CITY OF ALBUQUERQUE

February 20, 2020

Re: 6805 Academy Parkway West, Interior Remodel Phase 1
6805 Academy Parkway West, 87124
30-Day Temporary Certificate of Occupancy
Transportation Development Final Inspection
Engineer's/Architect's Stamp dated 8-8-19 (E17D073)
Certification dated 2-18-20

TCL

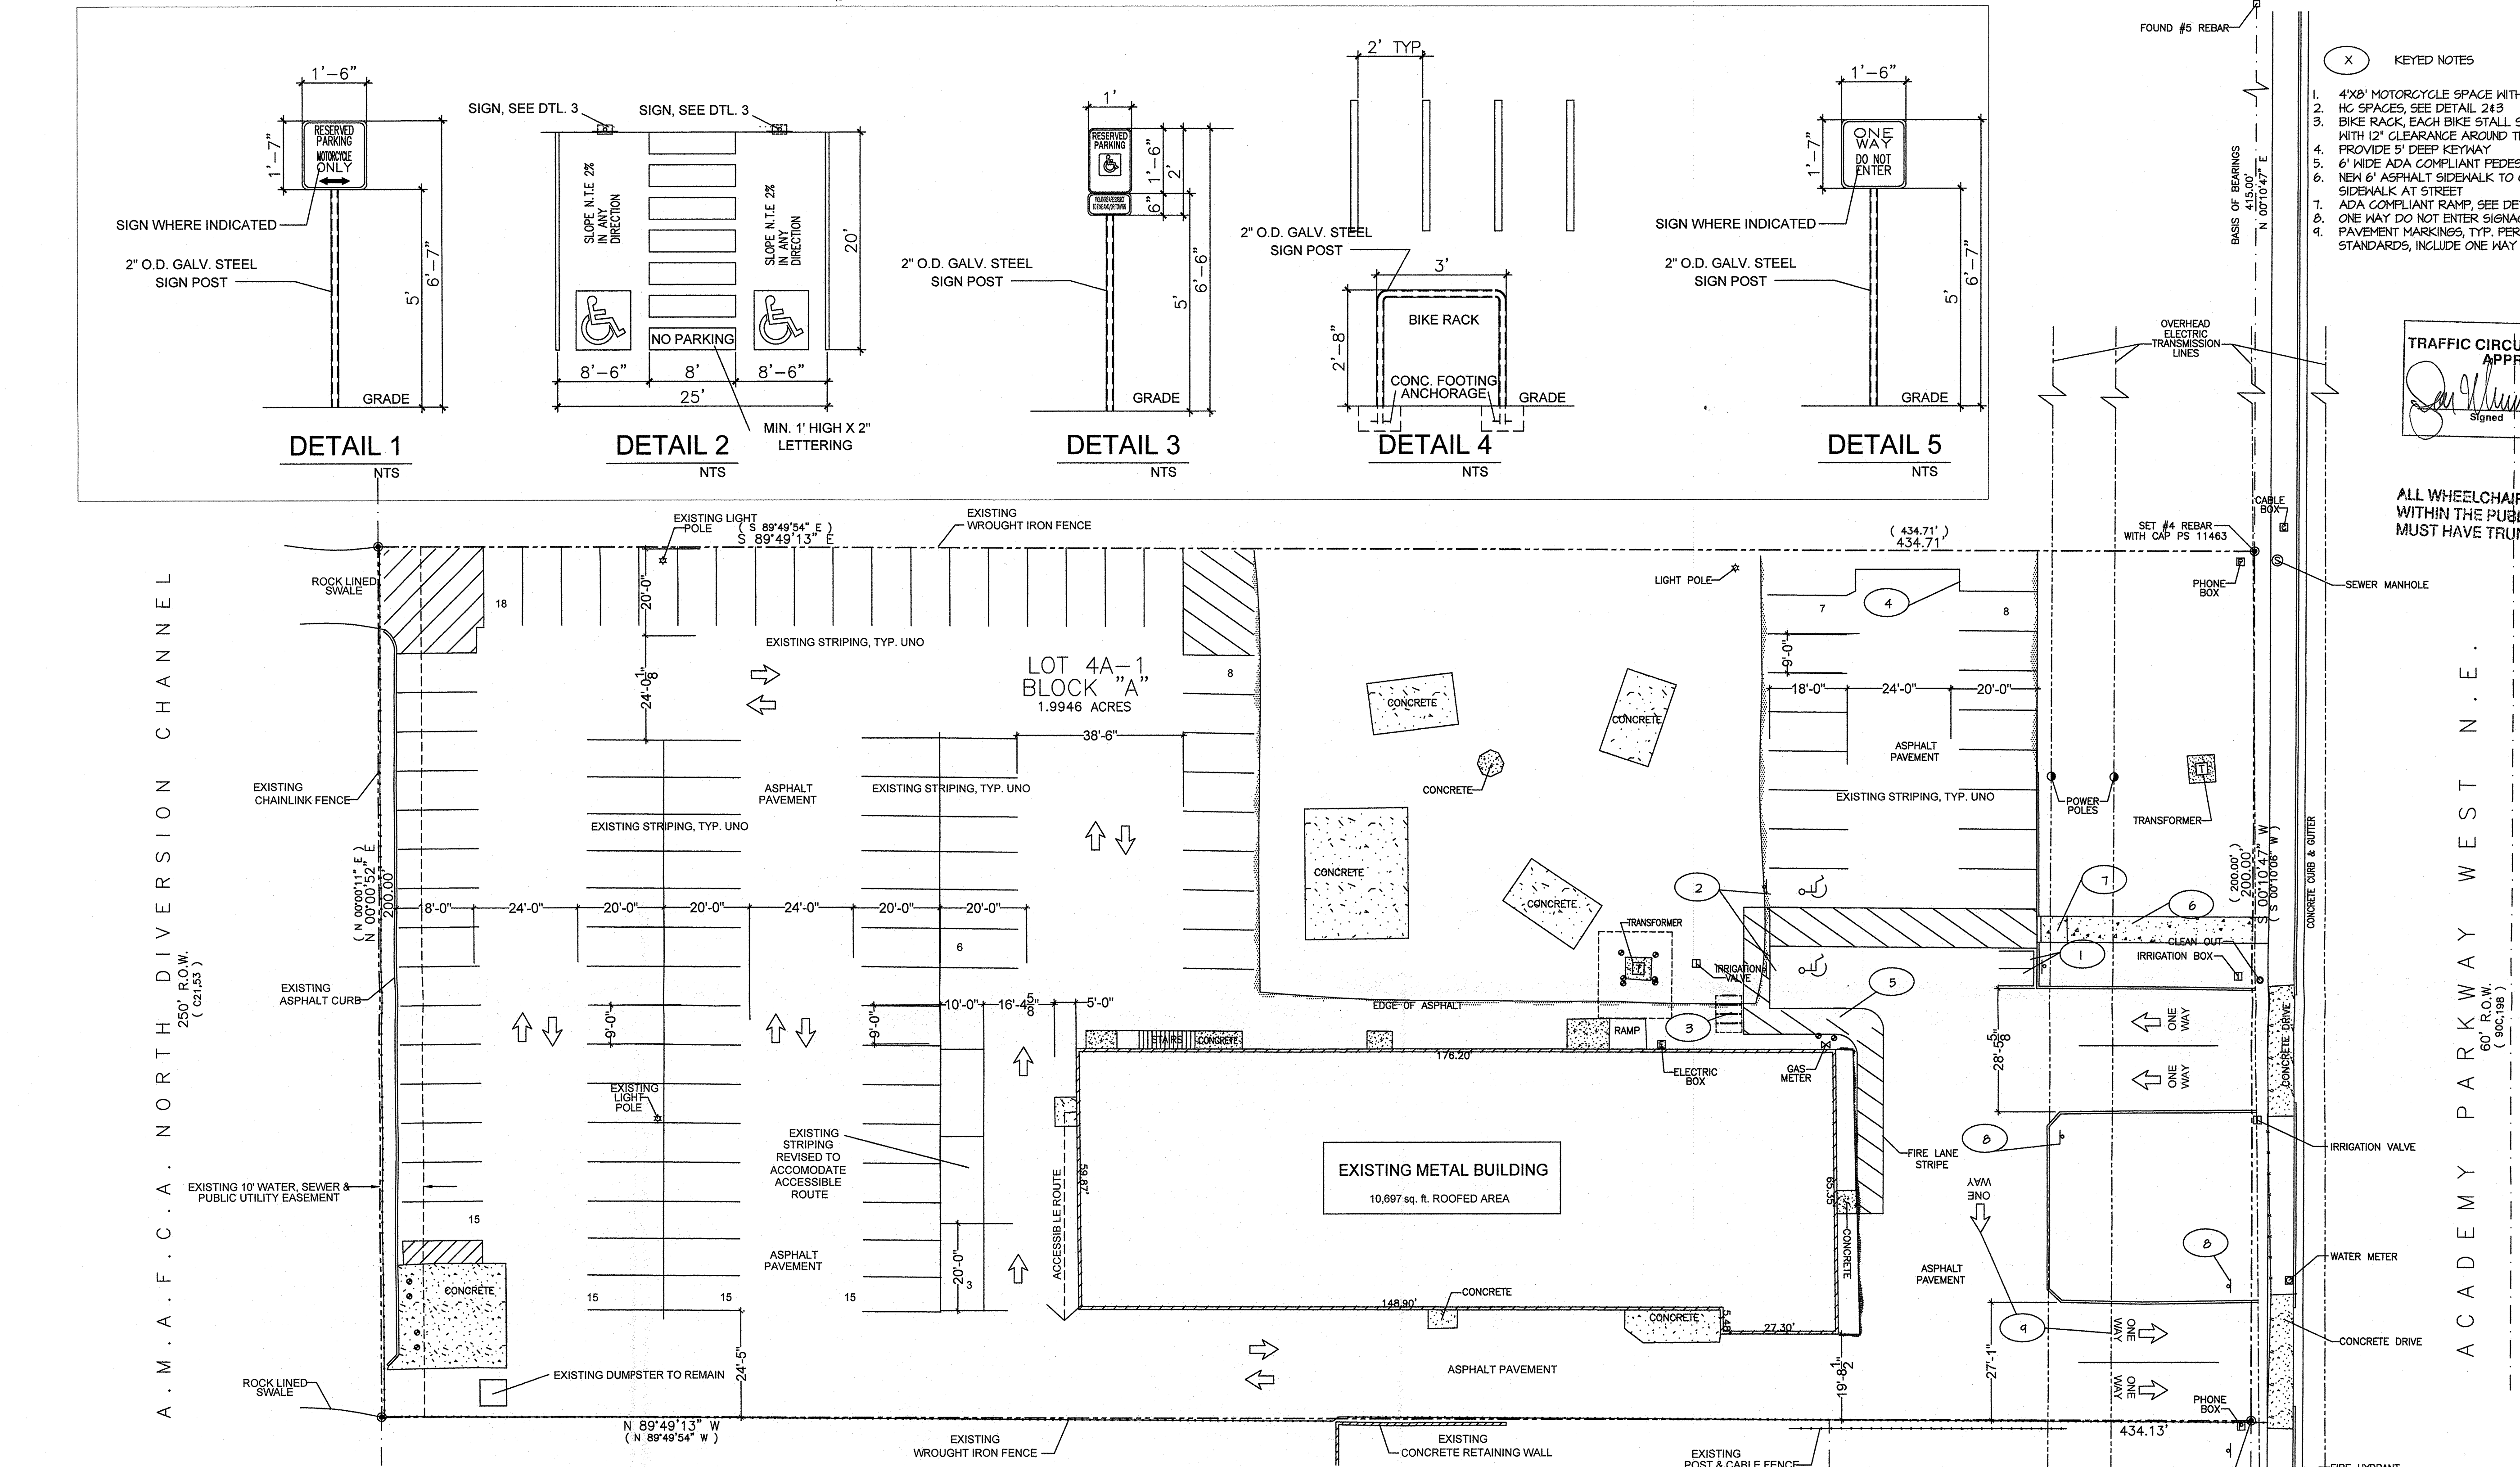
- Please relocate bike rack to location on approved TCL. Current location not within standards. Please see attached bike rack standards.
